CITY OF ALBUQUERQUE

December 1, 2015

**Re: Juan Tabo Hills Estates request for CLOMR
Engineer's Stamp Date-no stamp- (M21D018)**

Based upon the information provided in your submittal received 11-12-15, the above referenced CLOMR cannot be submitted to FEMA until the following comments are addressed:

Copyright © 2015 D. MARK GOODWIN & ASSOCIATES, P.A. All Rights Reserved.

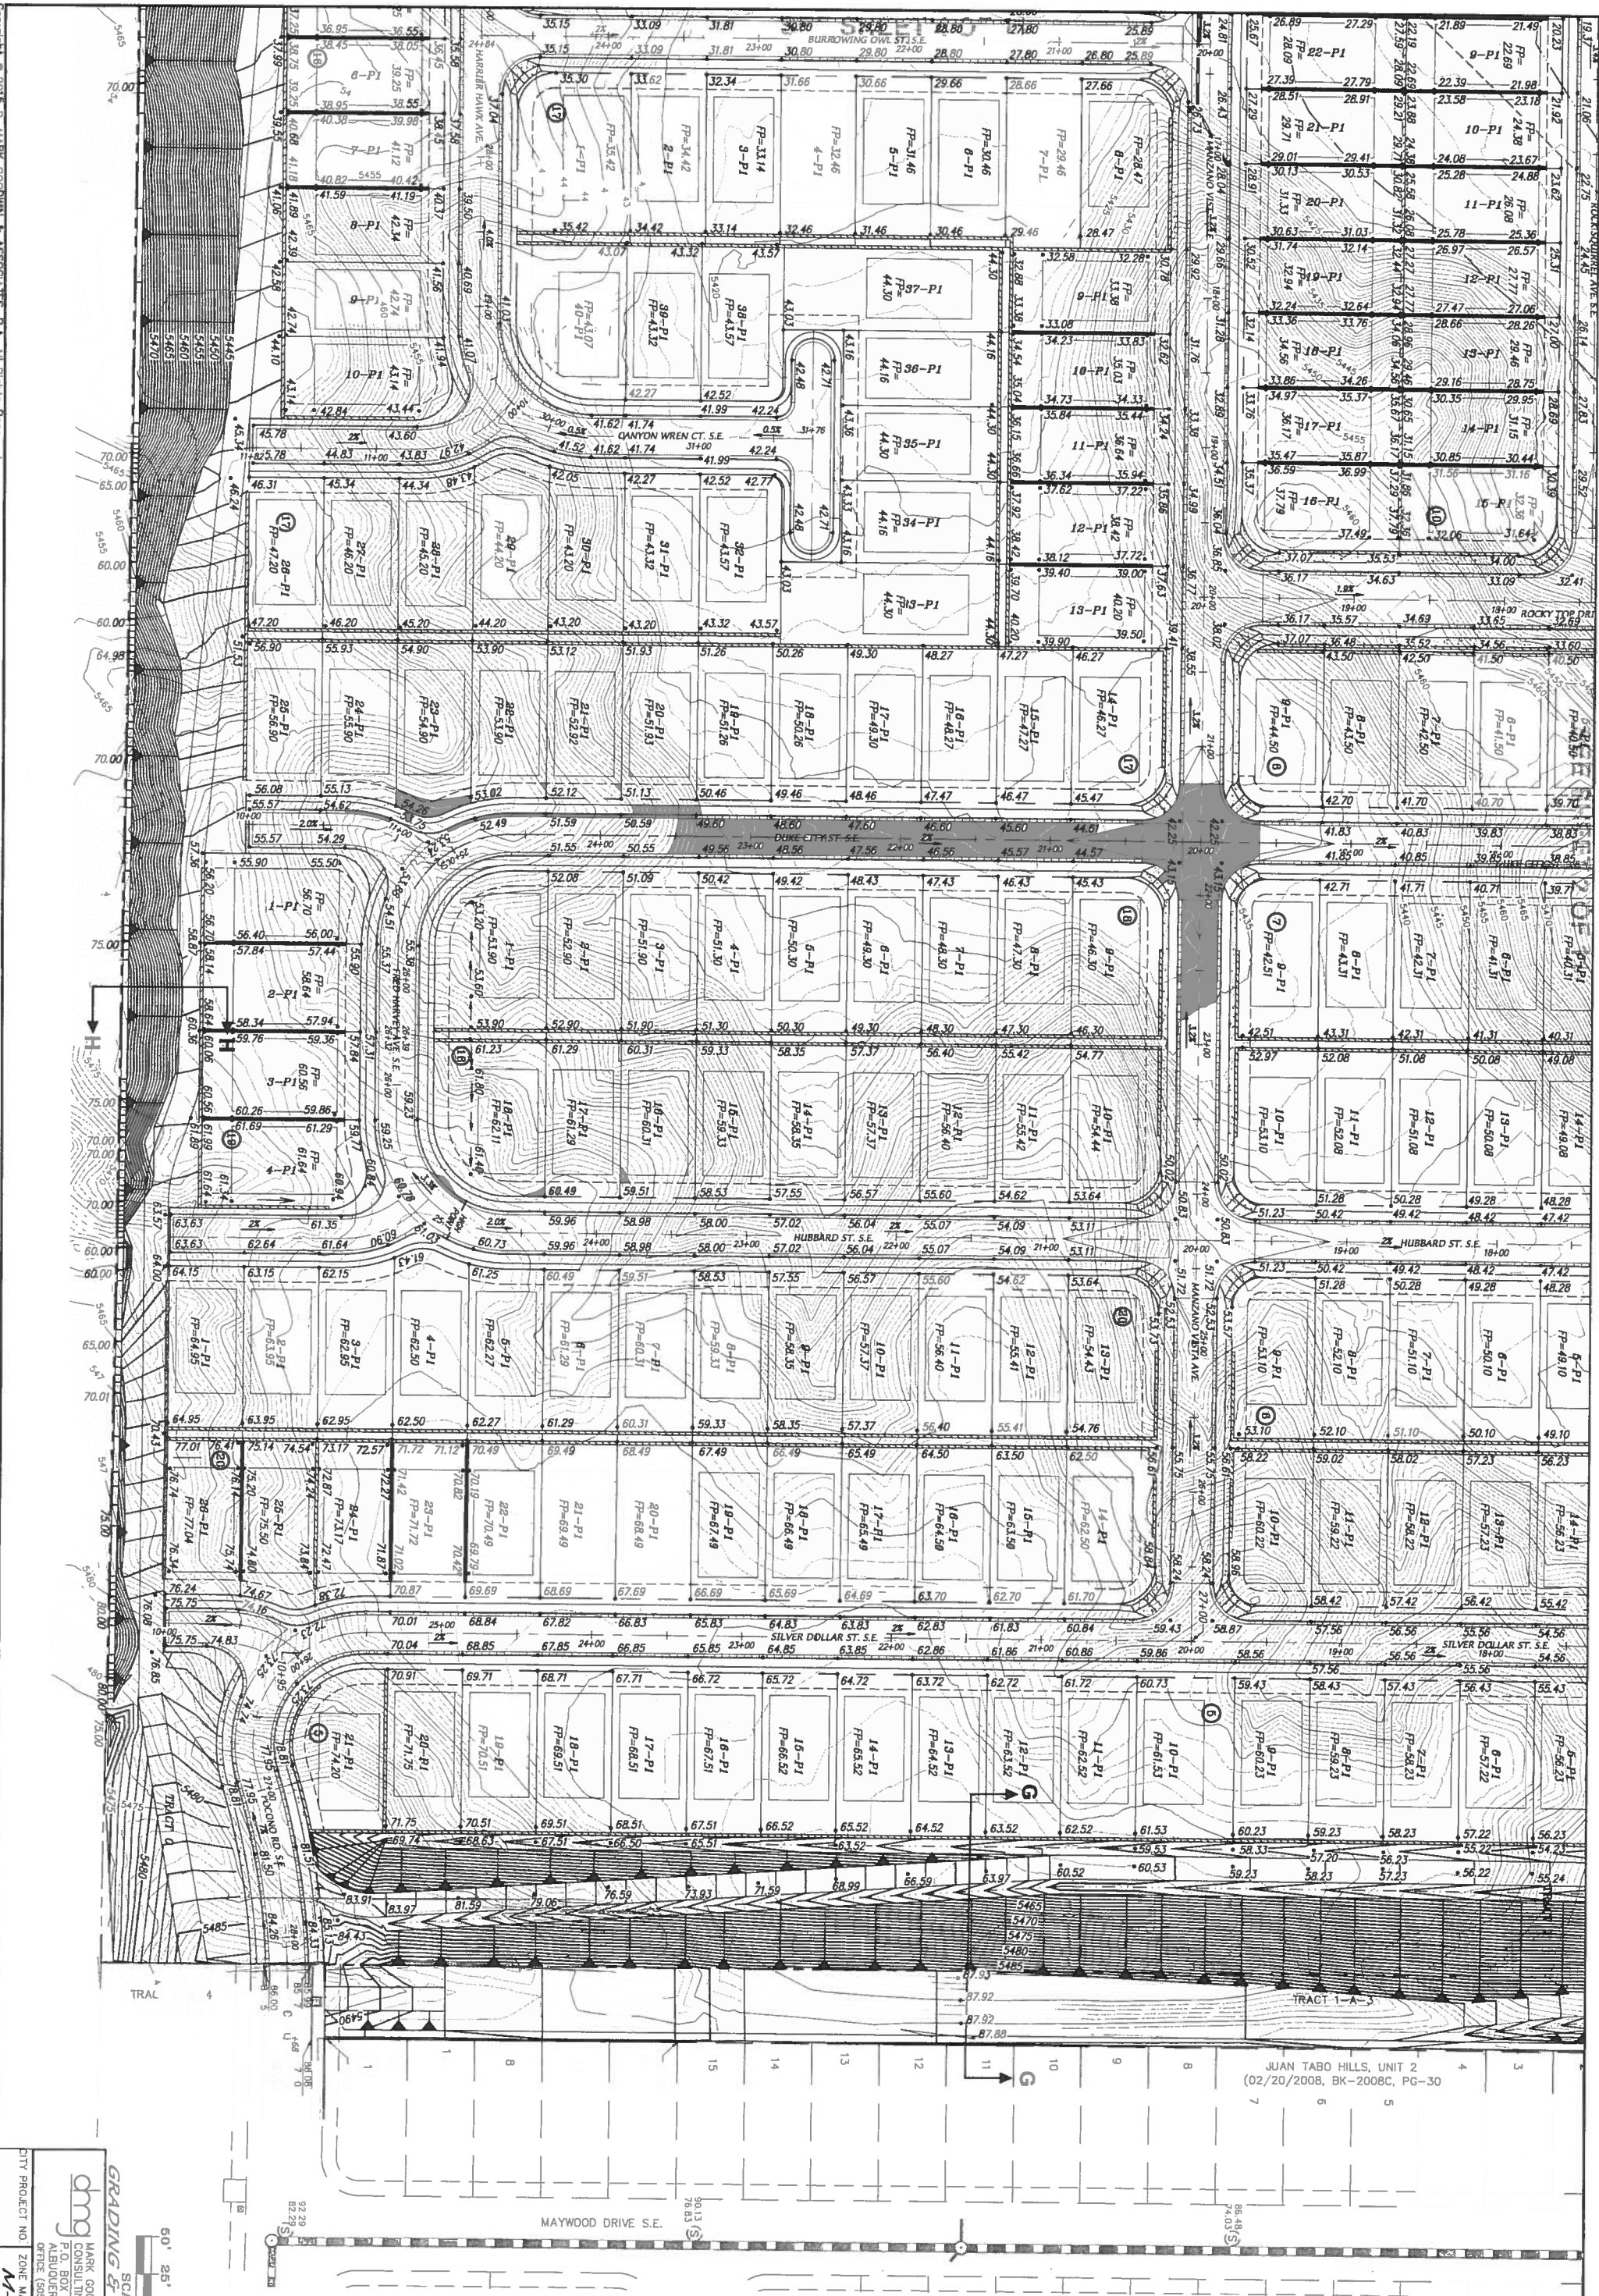
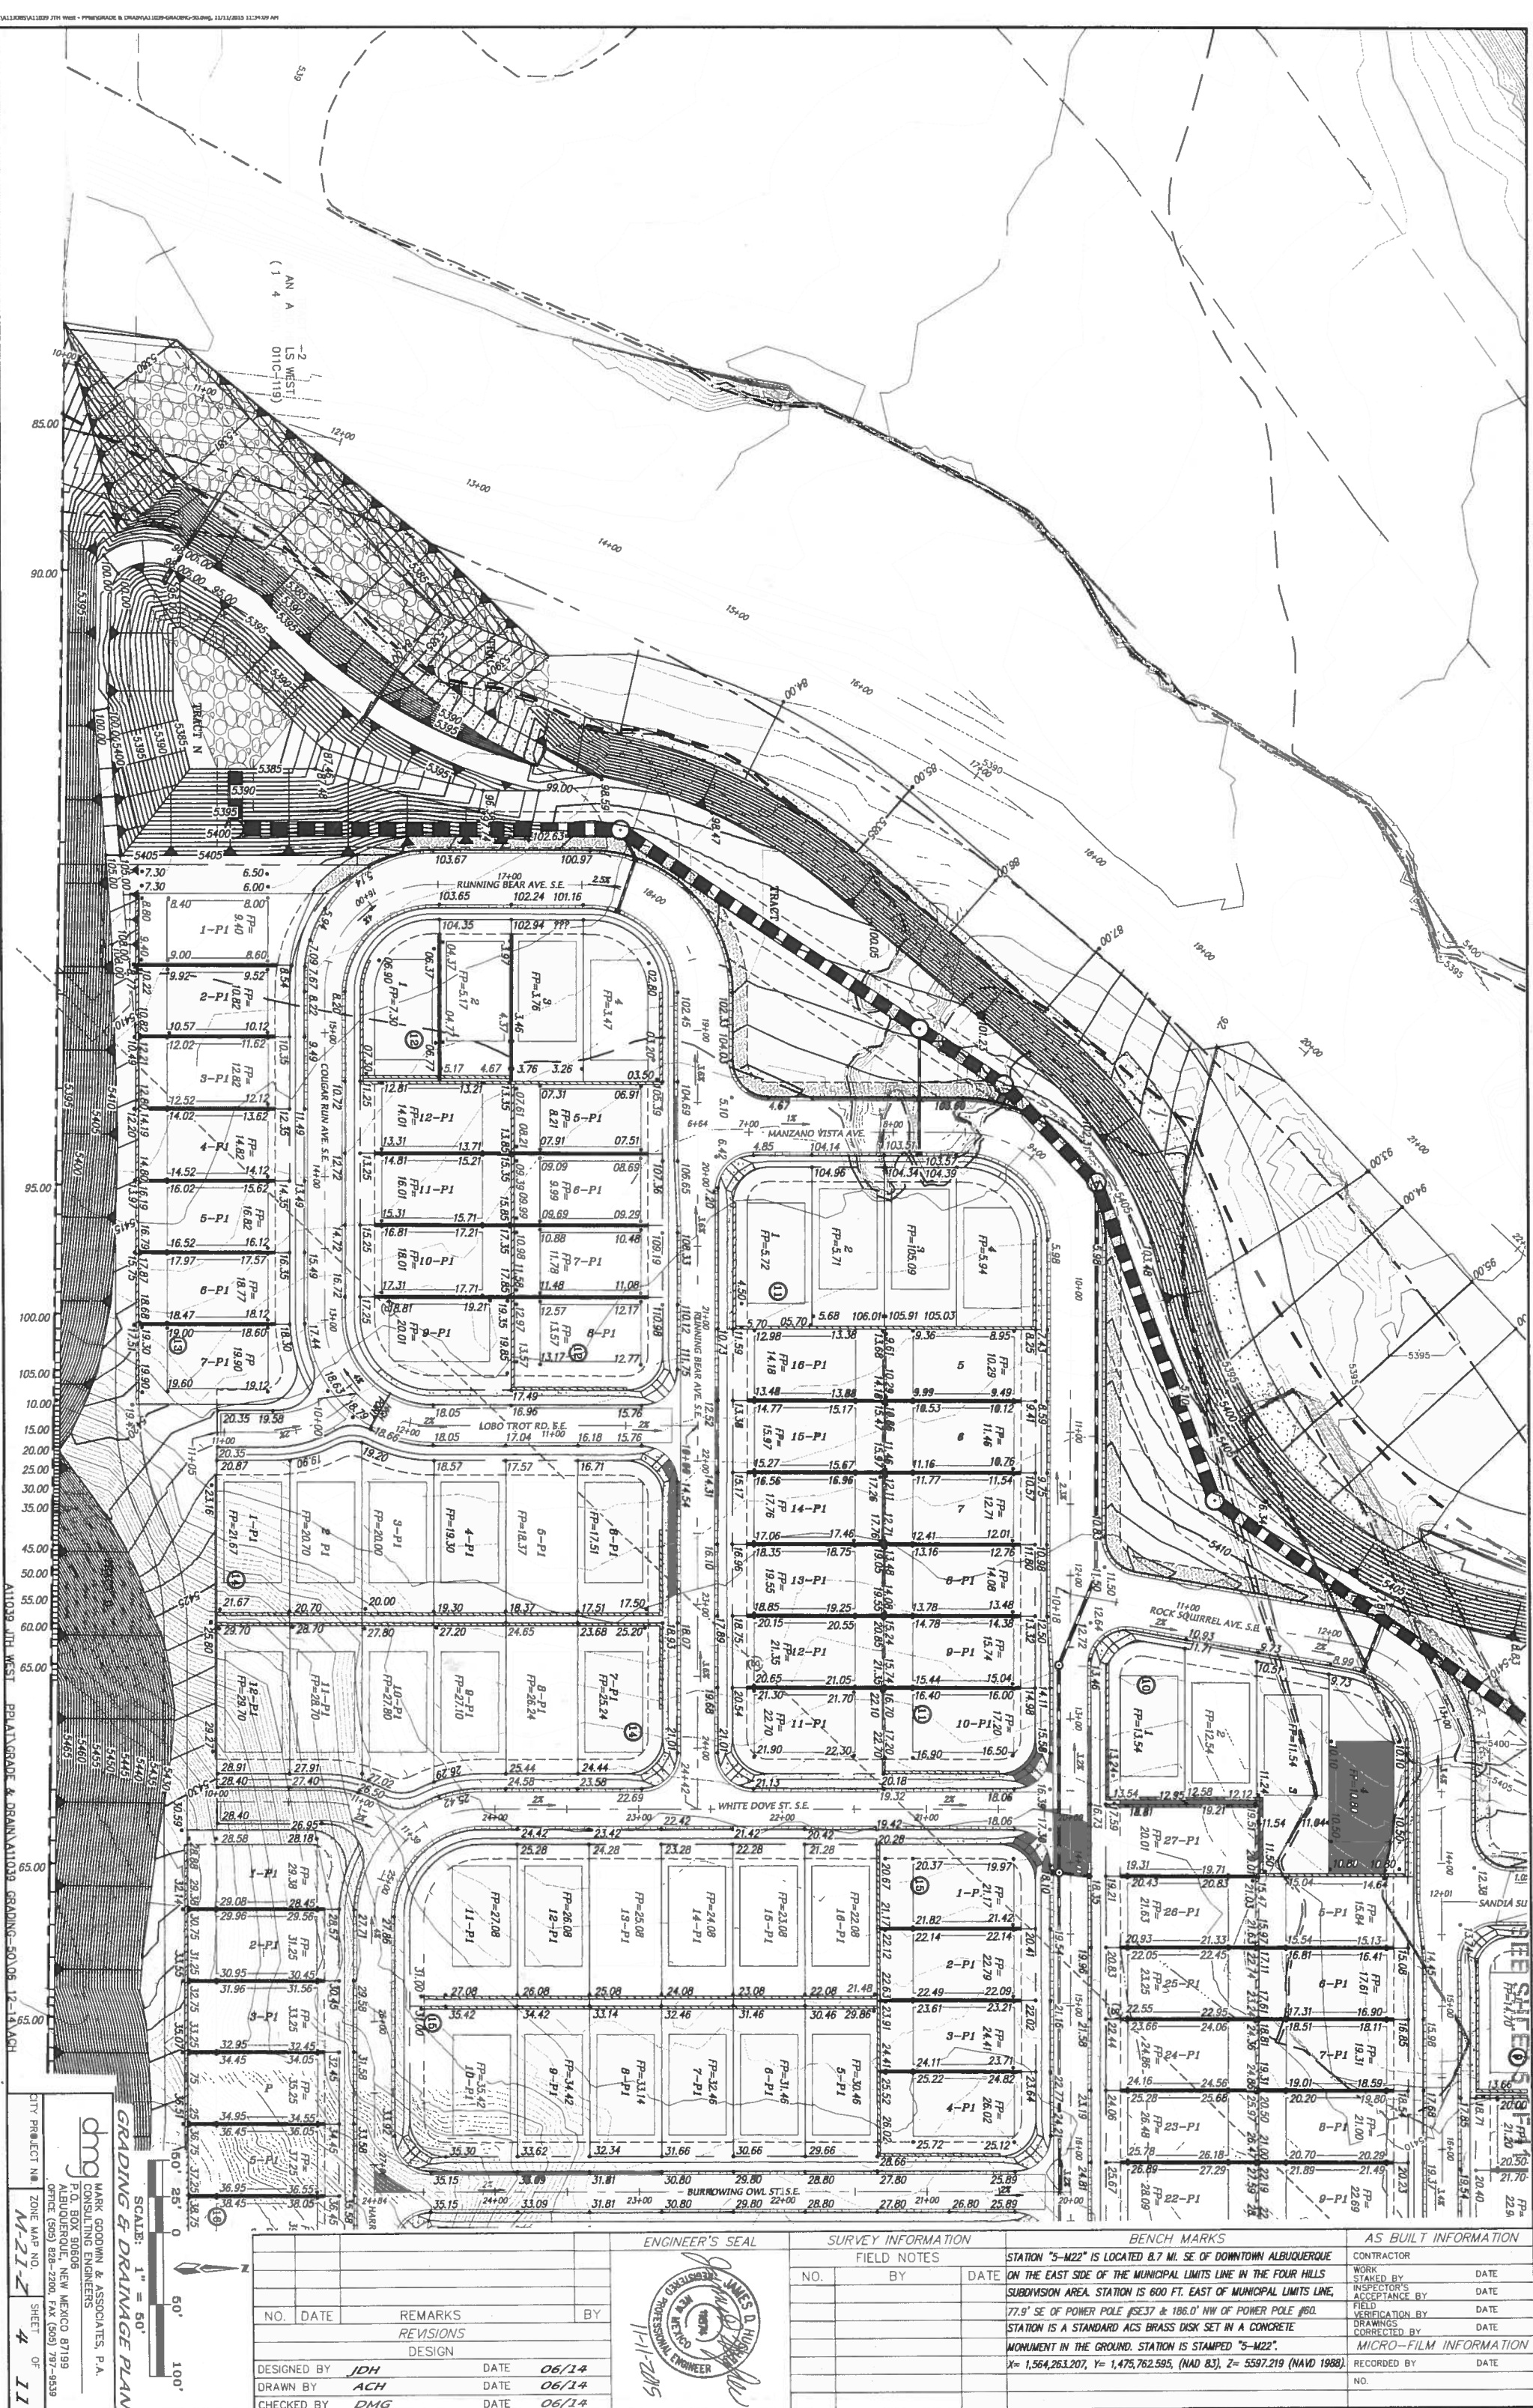
10. The Annotated FIRM is to be revised based upon above mentioned comments.
11. The following comments on the grading plan are related to the CLOMR.
 - a. At the northern end of the project, the scour wall is shown near the middle of the floodway and stops without tying into anything. What is to prevent the scour wall from being flanked? The scour wall should be closer to the edge of the floodway.

- b. Why is 8 to 10 feet of cut proposed at the north end? This will cause a head-cut to develop and result in erosion of the arroyo bed and additional sediment deposition downstream.

- c. Why is the arroyo bed proposed to be cut 5 feet or more from station 15+00 to 19+00? This will cause a head-cut to develop and result in erosion of the arroyo bed and additional sediment deposition downstream.

- d. Why is the arroyo bed proposed to be cut up to 9 feet near the SWQ pond? This will cause a head-cut to develop and result in erosion of the arroyo bed and additional sediment deposition downstream.

- e. A 4" outlet pipe seems extremely small for this size of a development.
 - f. There is some line work that looks like a storm drain south of the 4" pipe, but there is no build note.

- g. The bottom of the SWQ pond is below the water surface elevation of the arroyo. FEMA may consider the scour wall as a levee. The SWQ pond could be proposed as an AE zone (non-floodway), which may negate levee requirements. It is recommended to not propose a levee as the construction and design criteria is stricter than if a levee is not proposed.

- h. Please explain why it is necessary to propose so much cutting of the arroyo bed. The City would prefer to see a design that does not cut the arroyo bed to this extent, especially without grade control. The project site has lots of elevation gain above the arroyo. Why doesn't this design just increase in grade from the existing channel edge elevation?

- i. At station 15+60, an arroyo bed elevation of 84 is proposed, which is 8 feet lower than the arroyo bed elevation at station 14+75. The grading plan does not show the proposed grades from 84 to 92 and why is a hole proposed?

- j. Provide erosion protection where the 66" storm drains enter the arroyo. Provide method and calculations. An acceptable method is shown in "Urban Storm Drainage Criteria Manual, Volume 2" from Denver Colorado.

- k. Erosion protection criteria specified in comment J above also applies to the outlet(s) from the SWQ pond and additional outlets to the arroyo.
 - l. A different line type for the floodway is shown on the east side of the floodway.

- m. Once the WSE elevation is corrected to NAVD 88, the WSE can be compared to the grading plan.

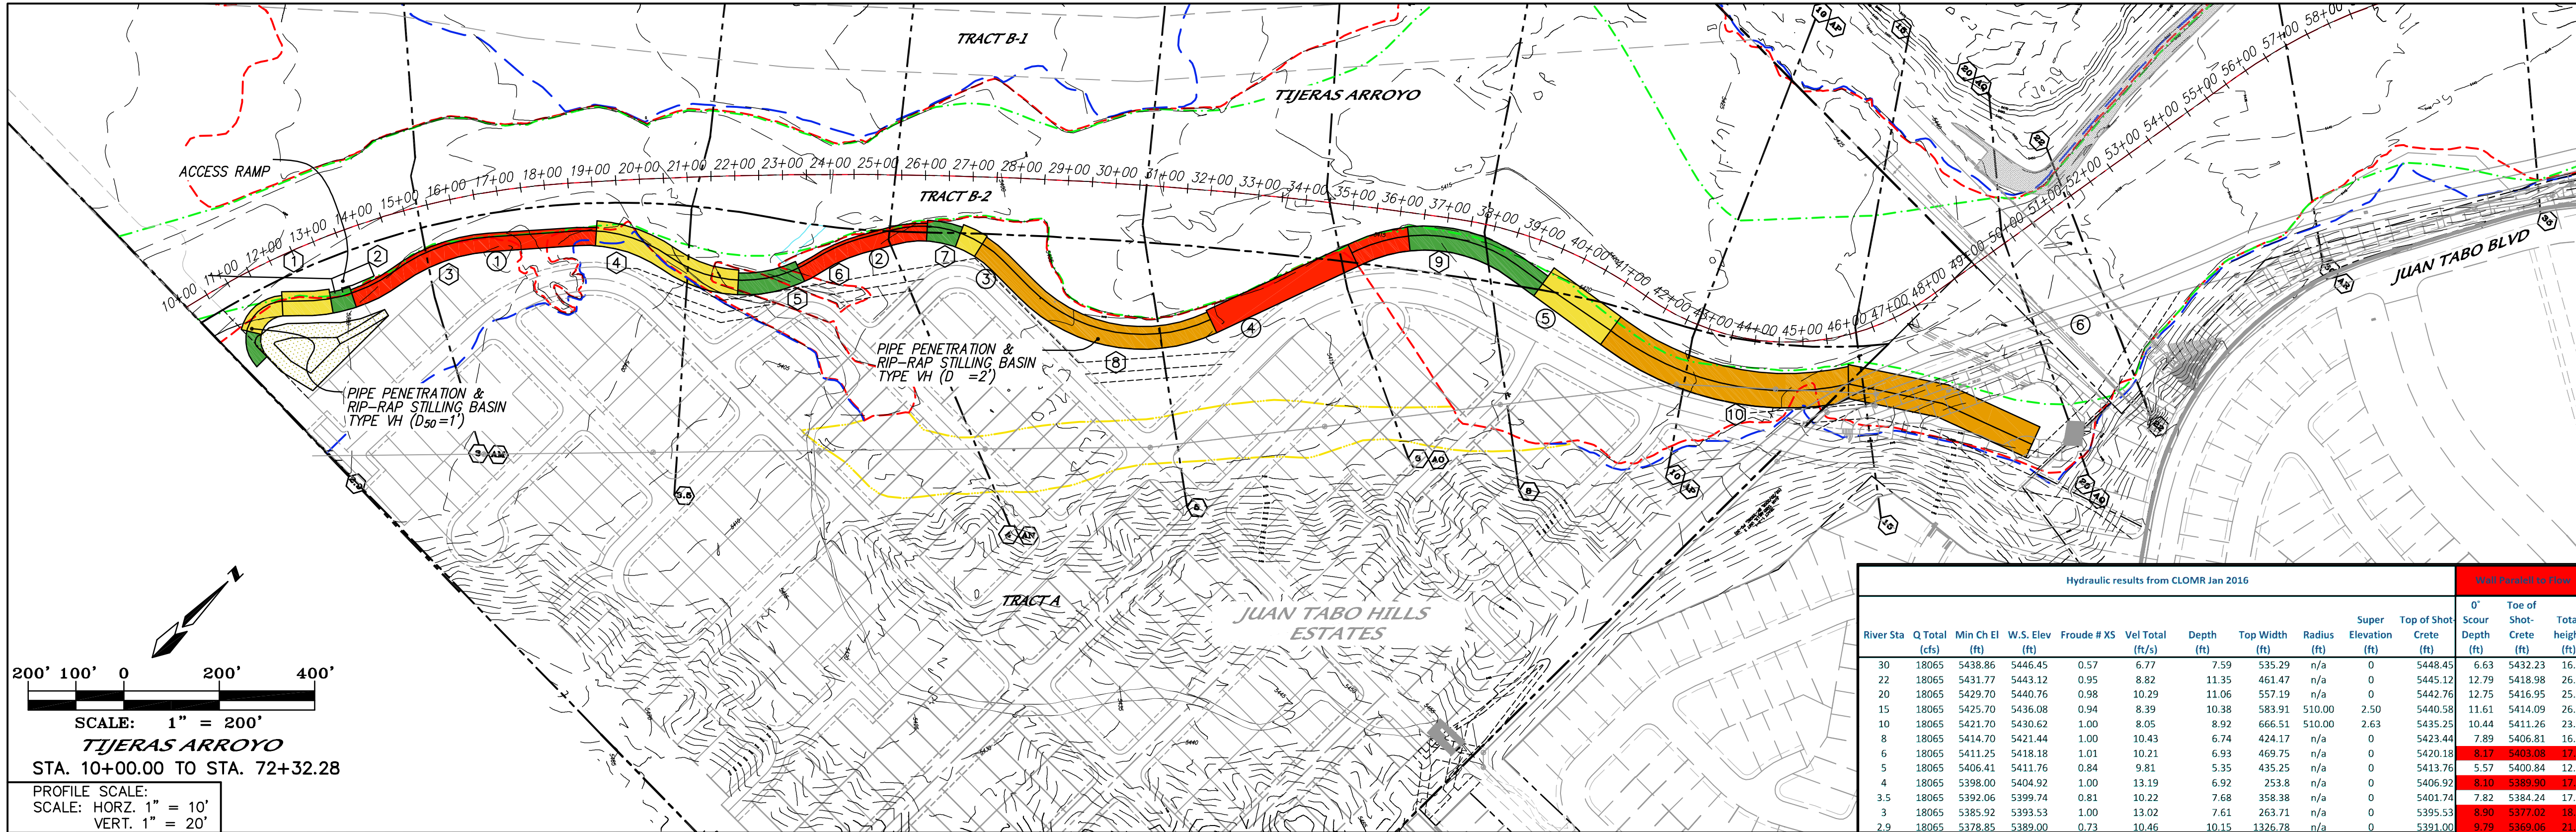
5. Label all HEC_RAS sections with RS and/or FEMA x-section.
6. The Bank Protection Plan and Profile sheet does not show the floodway. There is a legend for the line-type, but no floodway line on the sheet. In addition, the Waters of the U.S. information should be removed for clarity.
